Application No: LU/383/21/PL
Site Address: 9 North Street Littlehampton BN17 6JJ
Description of works: Workshop extension (resubmission following LU/216/21/PL). This site is in CIL Zone 5 (Zero Rated) as other development.

Thank you for your internet representation made on 6th January 2022 which has been recorded as an objection with the comments as follows:

Revision	Date	Description
Client: The Car Surgery, 9 North Street, Littlehampton, BN17 6JJ		
Project: Extension to Rear		
Drawing Title: Proposed Ground Floor		
Scale:	Date:	Drawn By:
1:100	17/06/2021	BE
Drawing Number:	Revision:	
1410/003	-

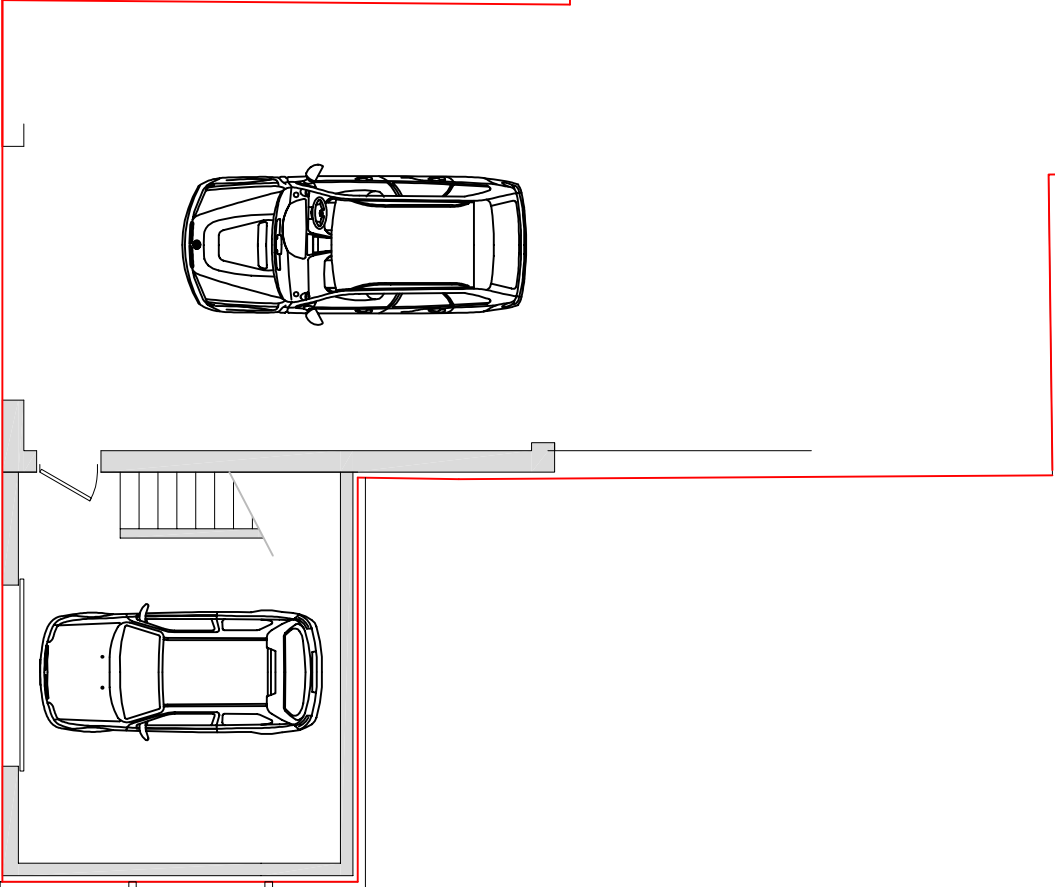
The Town Council's Planning and Transportation Advisory Group considered this application at their meeting held on Monday 4th January 2022 and object to the application on the grounds that parking provision would be lost and that as the resubmission excludes staff room provision, lack of facilities, particularly toilet/bathroom for staff.
